Our Ref: F/1/19/PL
Your Ref:

Town & Country Planning Act 1990 (as amended)
Town and Country Planning (Development Management Procedure) (England) Order 2015
Application for Planning Permission

Development Change of use from B1/B8 (Business/Storage or distribution) to D2 (Assembly & Leisure)
Location Unit A1 Ford Road Industrial Estate Ford Lane Ford

CLIENT:		
Matthew Ryan 1 Broomfield Way Bognor Regis PO22 8AQ		
PROJECT:		
Unit A1 Ford Industrial Estate Ford Lane Ford Arundel BN18 0UZ		
CHECKED:	DRAWING NO:	REV:
-		
DATE:	MR-P-1	
3-1-19		
© KMH Construction Ltd

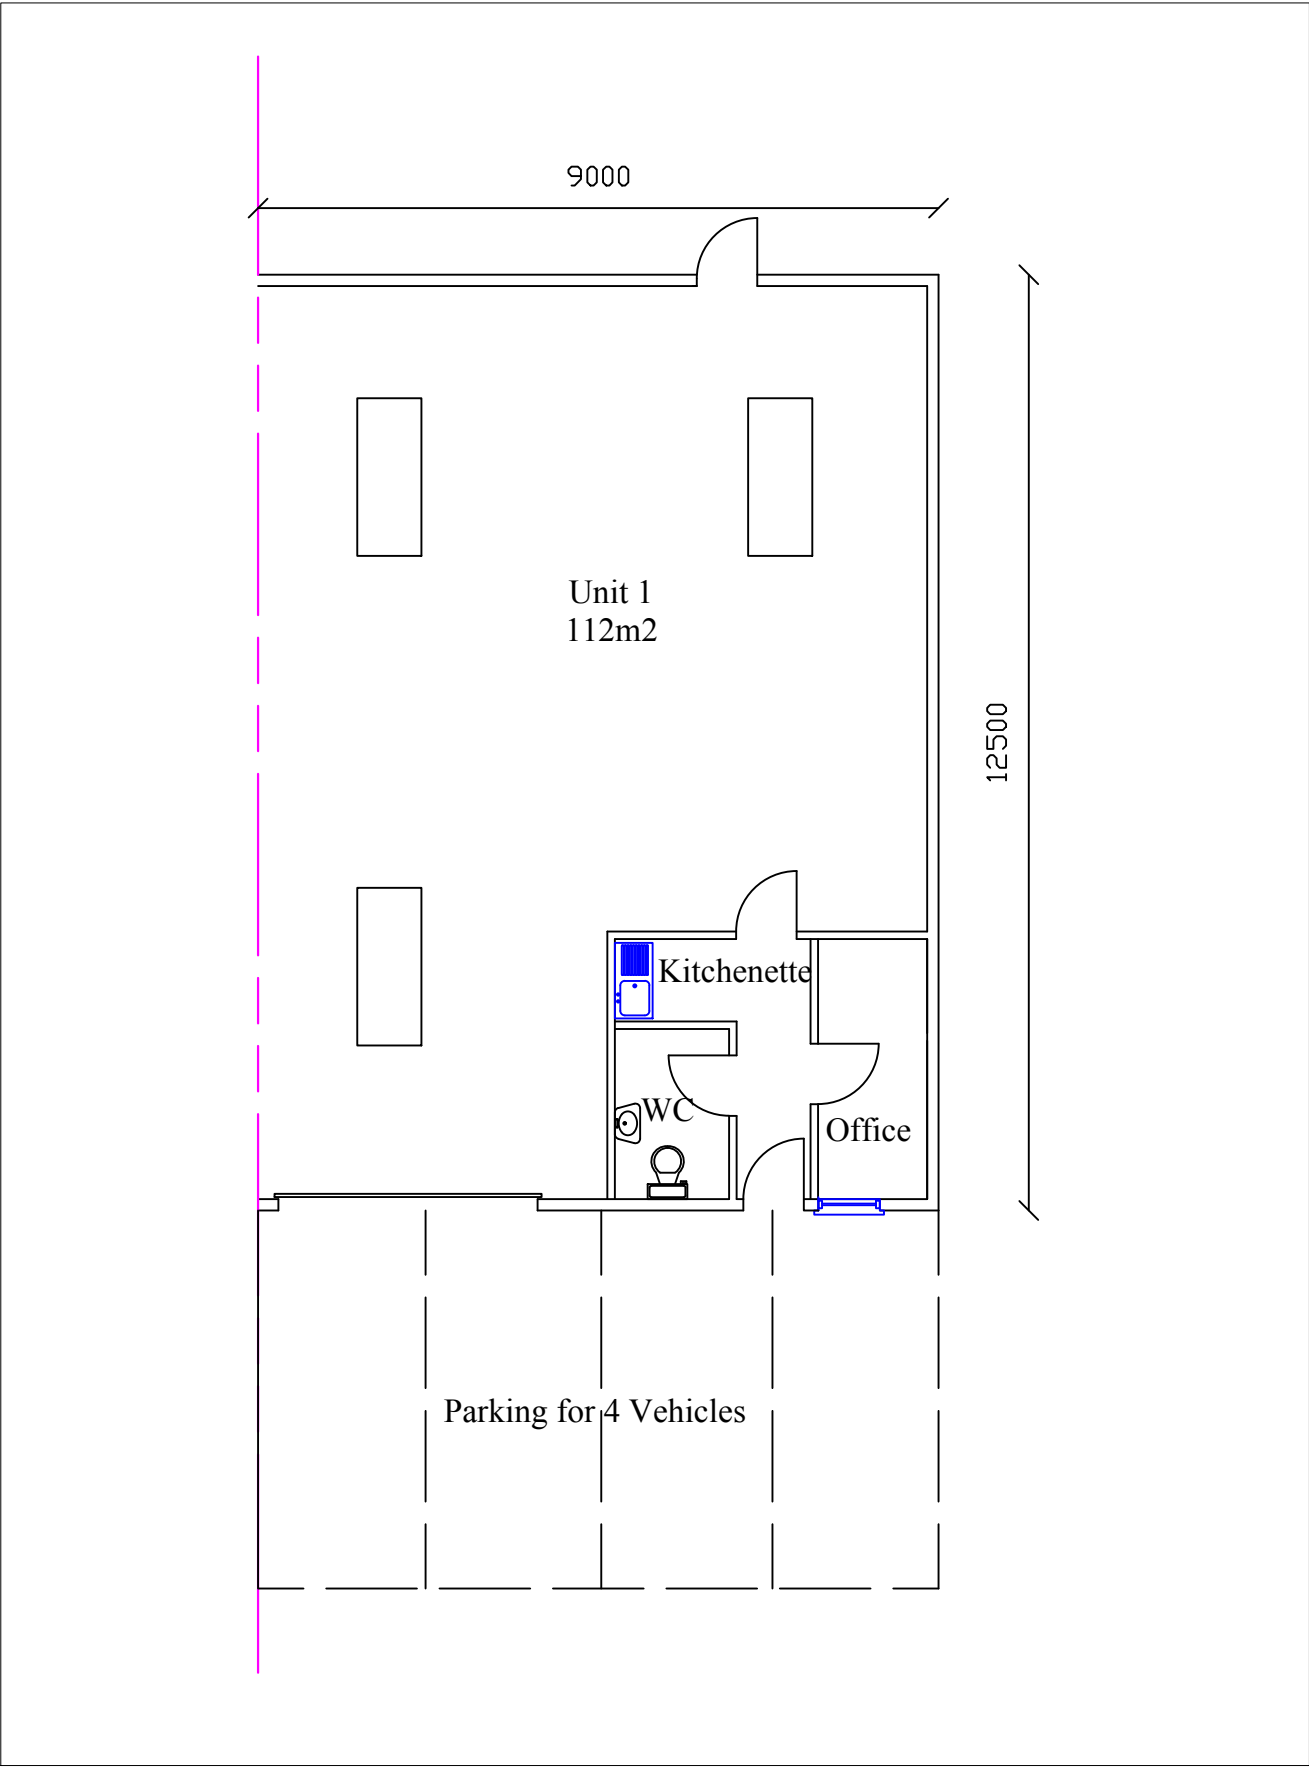
Please forward amended floor & elevations titled 'Existing & Proposed'. Does the 1st floor plan form part of the application? If so, please provide a floor plan titled accordingly.

The elevation plan has pixelated. Please forward revised drawings accordingly.

CHECKED: -	DRAWING NO: MR-P-2	REV:
DATE: 3-1-19

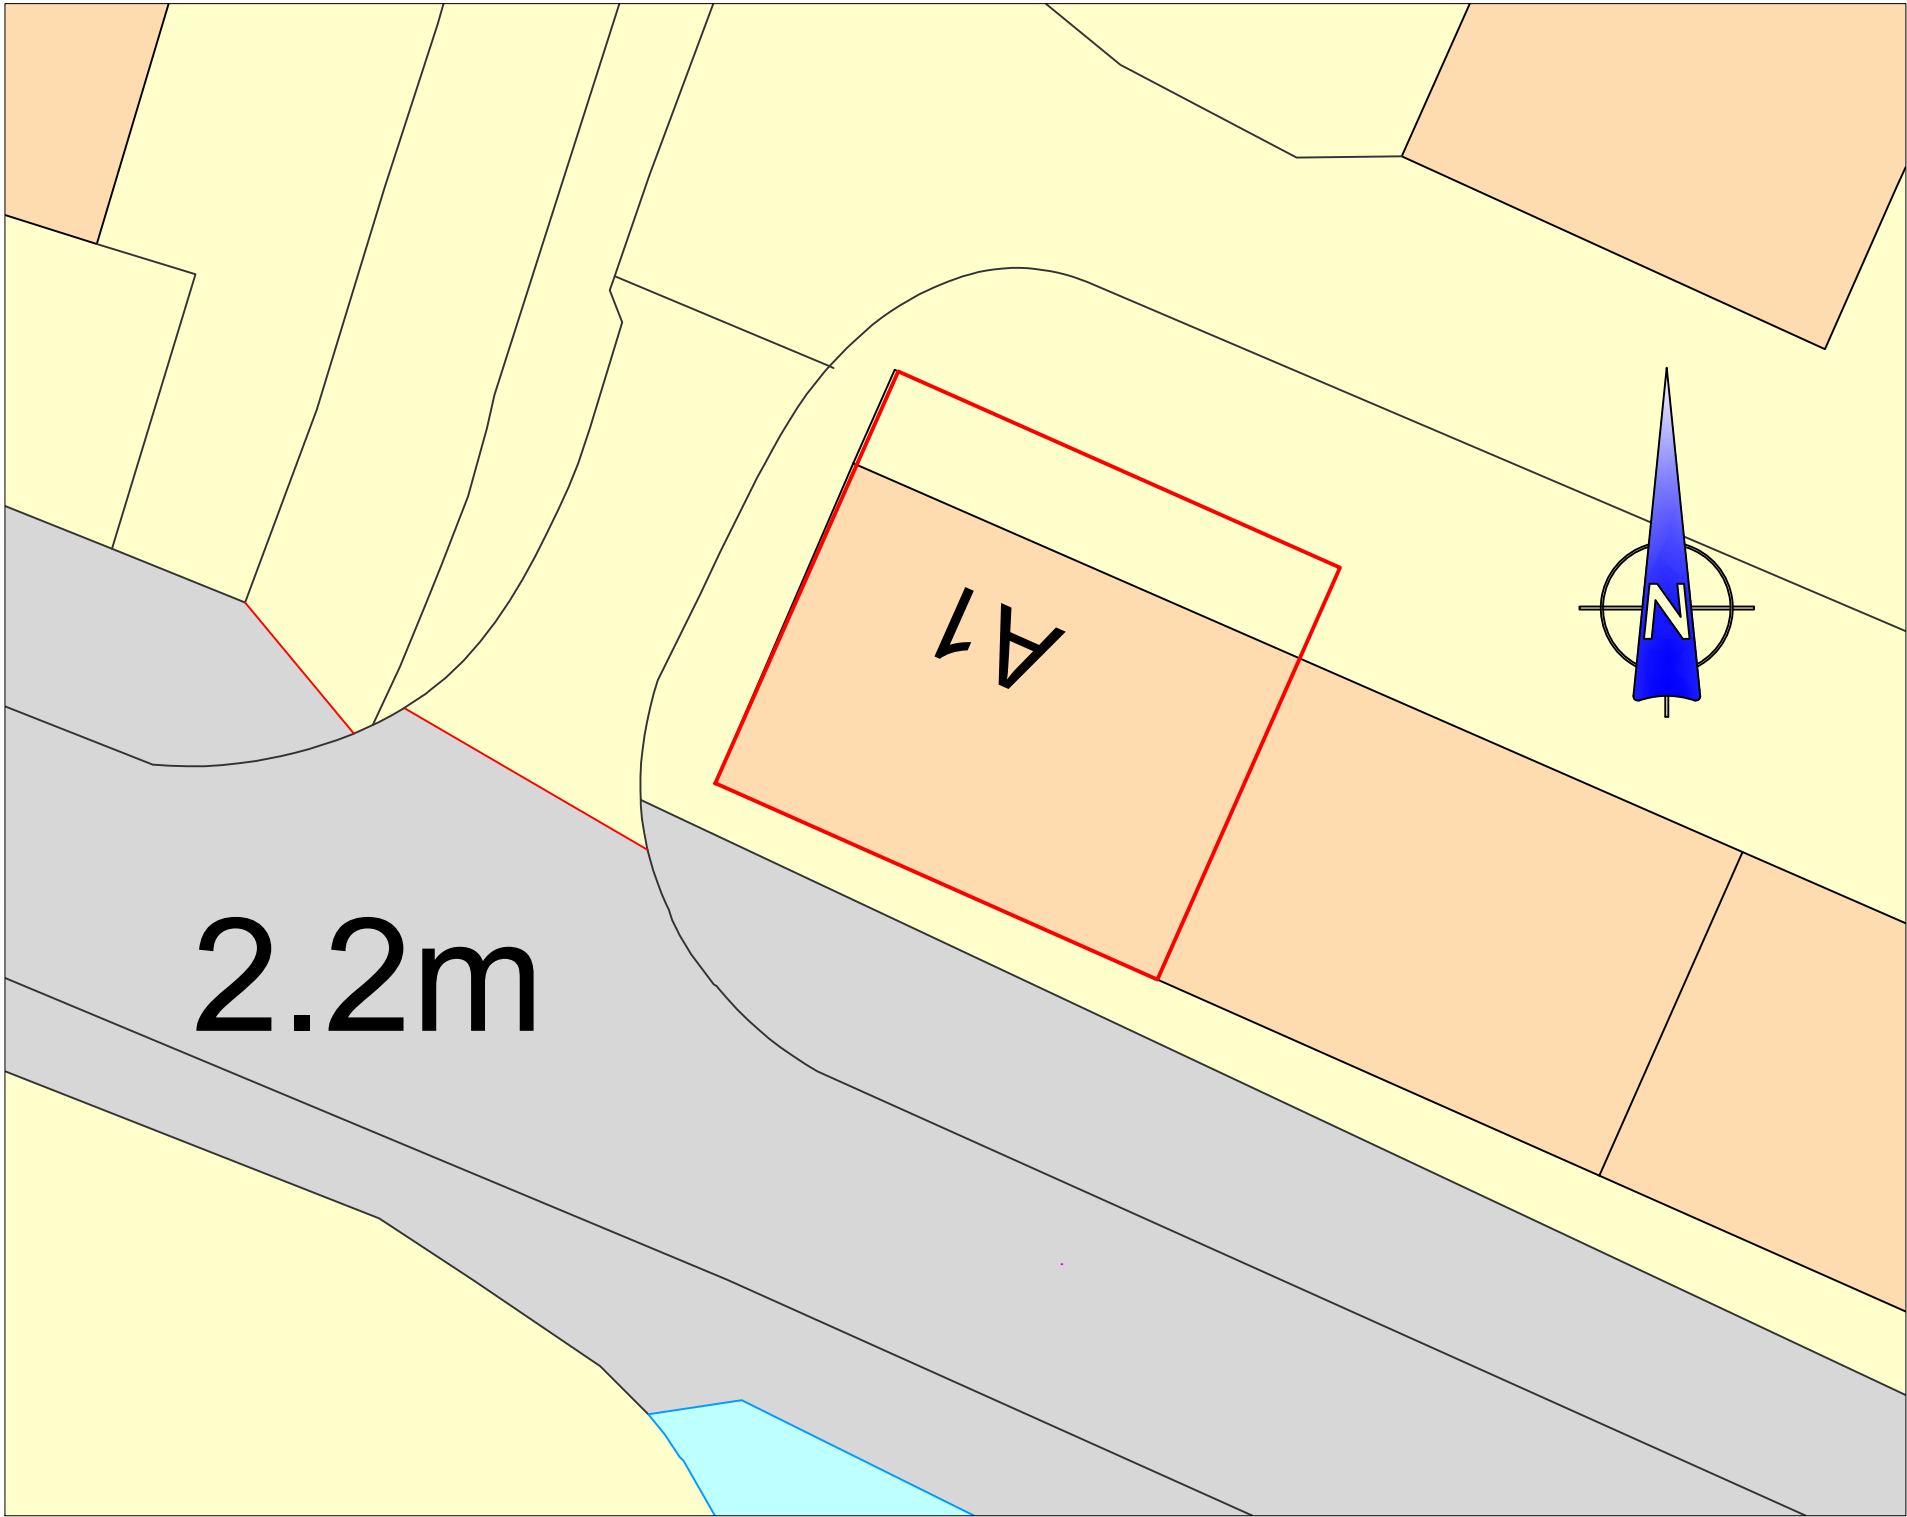
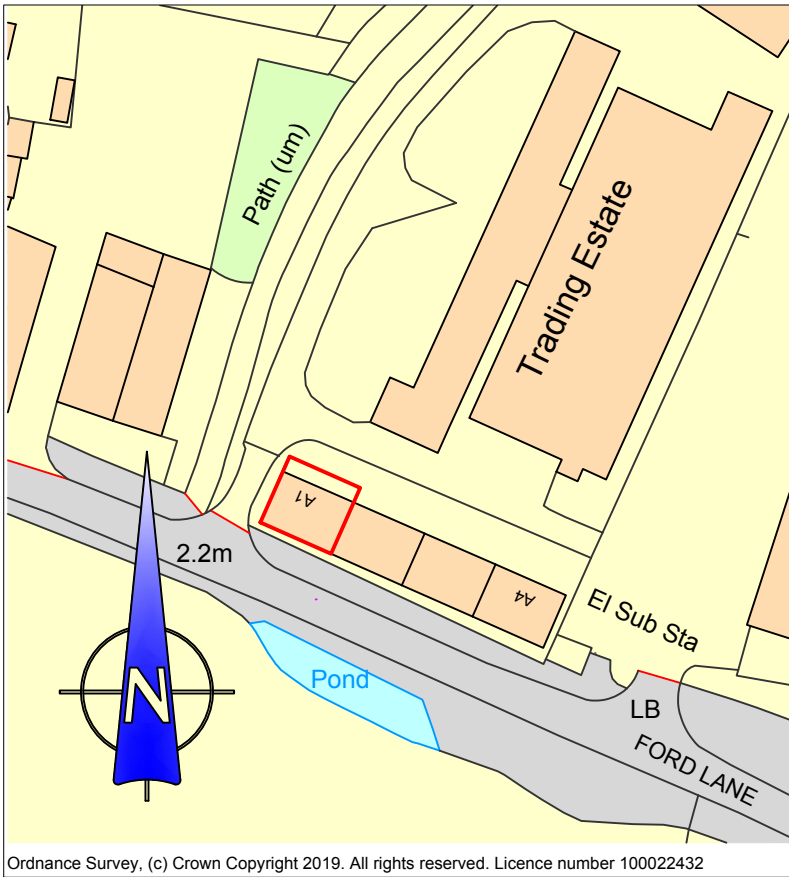
Location Plan

Please submit 1 electronic or 3 paper copies of an amended location plan at a scale of 1:1250 or 1:2500 for rural areas showing 2 named roads. Further details of what must be included on the plan can be found in the National Validation Requirements.
